John Brown Architecture Ltd
The Bricks
Manor Barn Farms
Selsey Road
Donnington
PO20 7PL

Our Ref: CM/37/19/DOC

Approval of details reserved by condition imposed under ref CM/28/17/PL relating to Condition Nos 3 - schedule of materials & finishes, 4 - construction method statement & details, 6 - ecological watching brief, 7 - bats/owls habitat and 8 - landscape scheme.

Ryebank Farmhouse New Barn Grevatts Lane Climping BN17 5RF

APPENDIX B

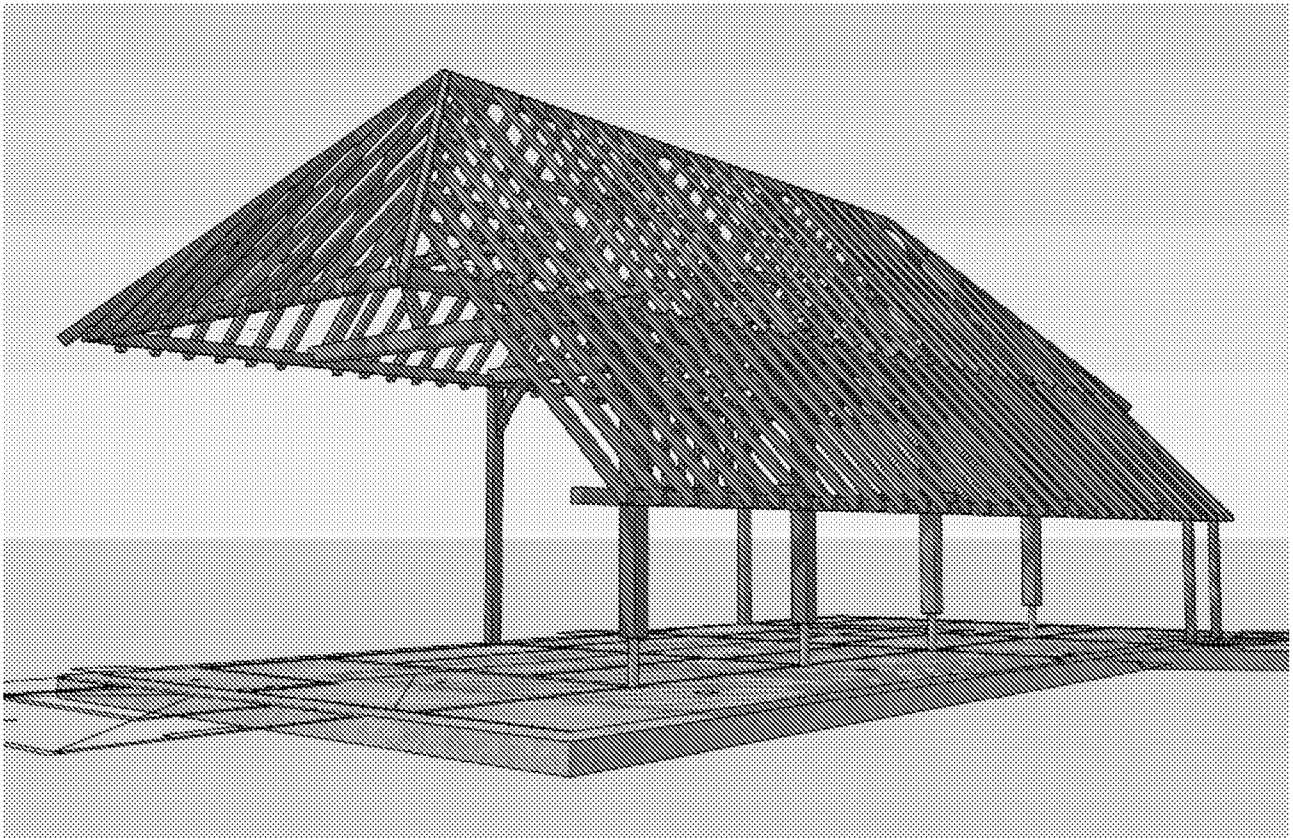
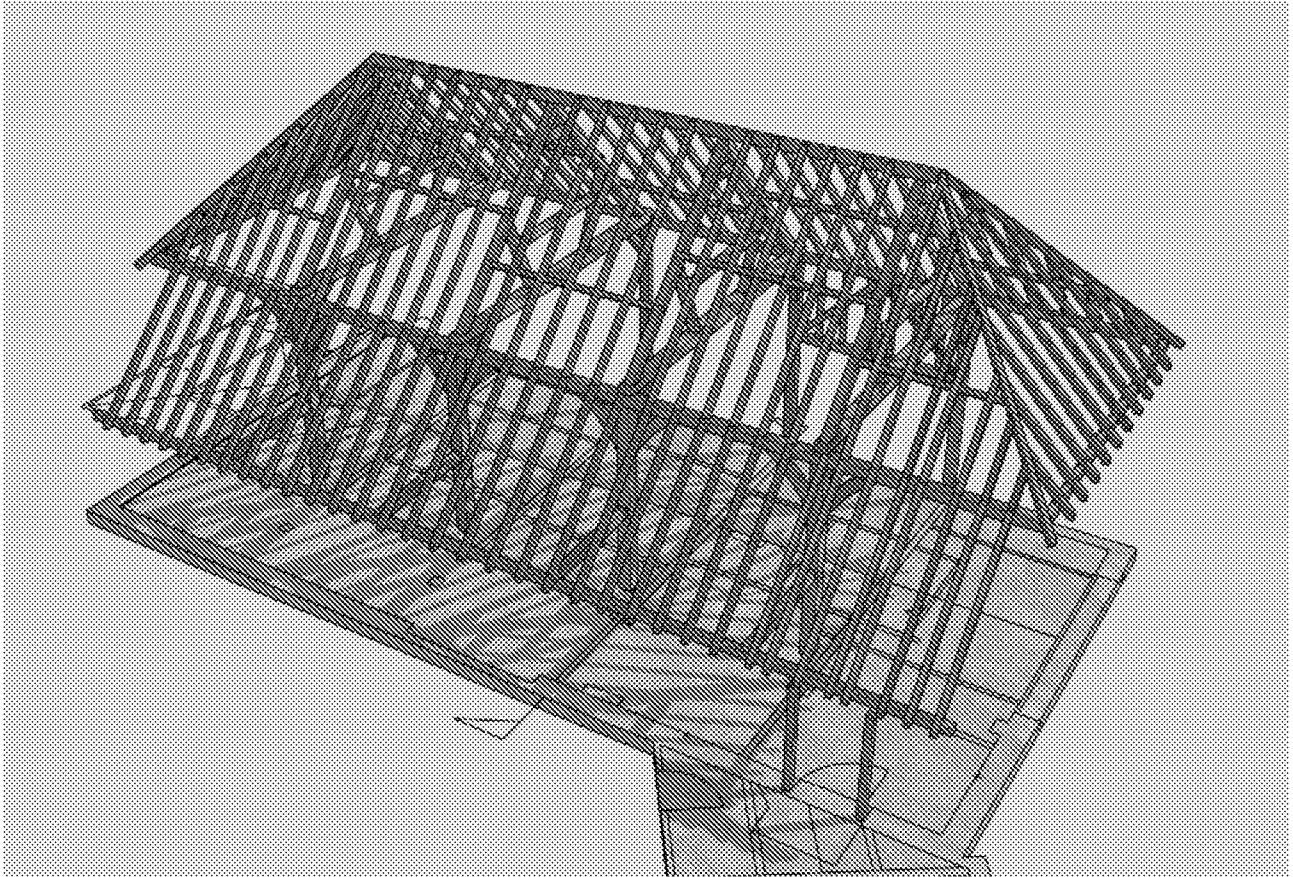
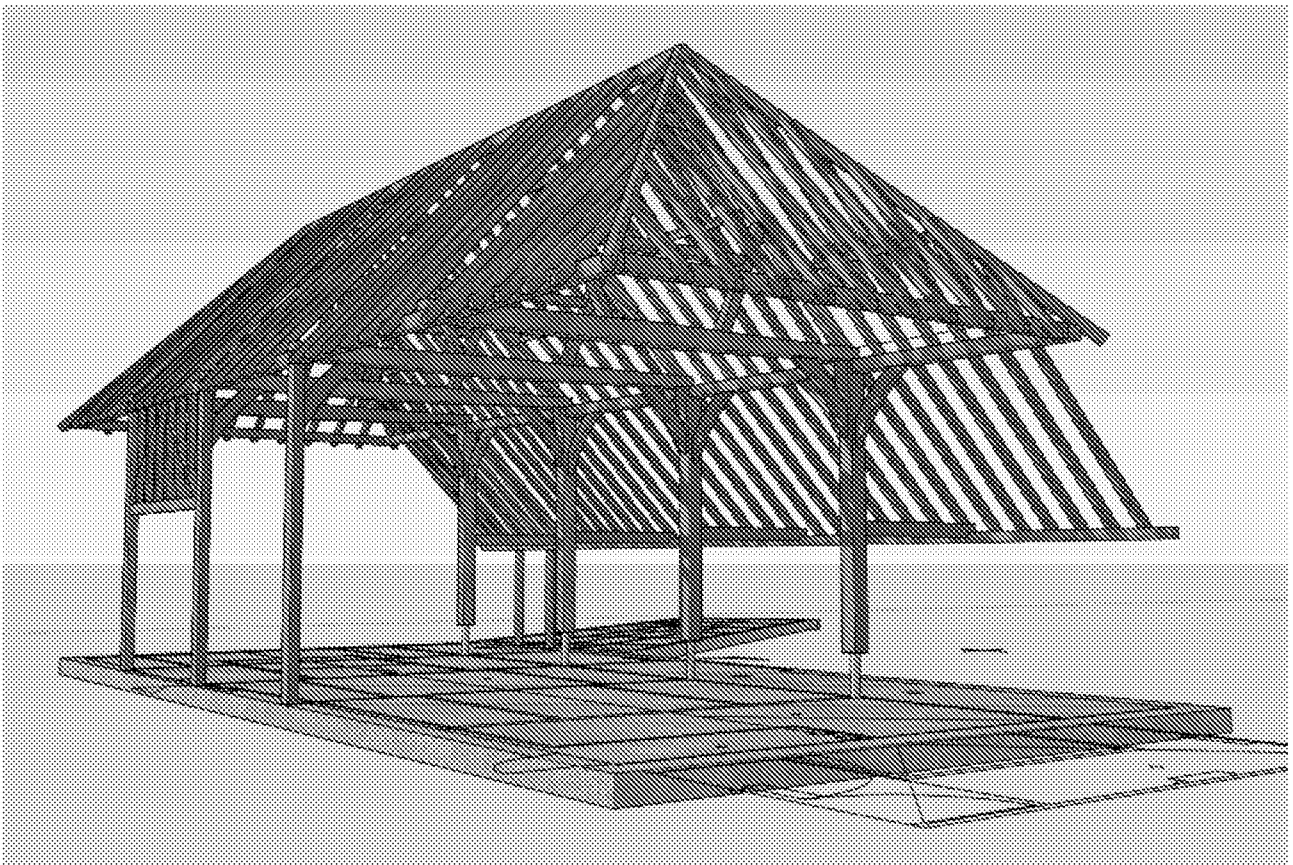
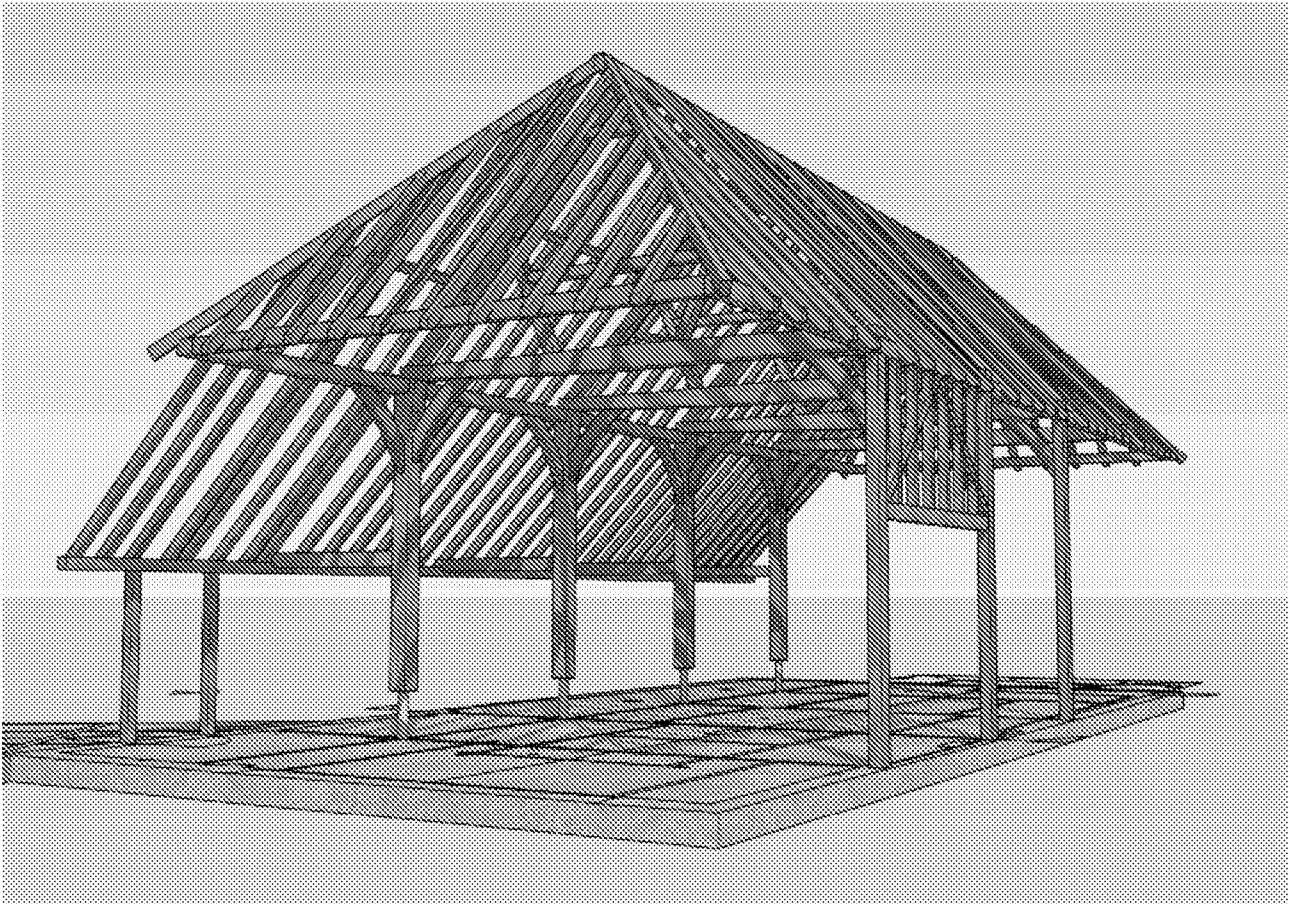
- the extent of underpinning proposed.
- the masonry panels requiring rebuilding are not clearly identified.
- the stud panelling referred to in the survey as 'to be repaired' is not identified for retention.
- the main doors are not identified for retention or storage and reuse.
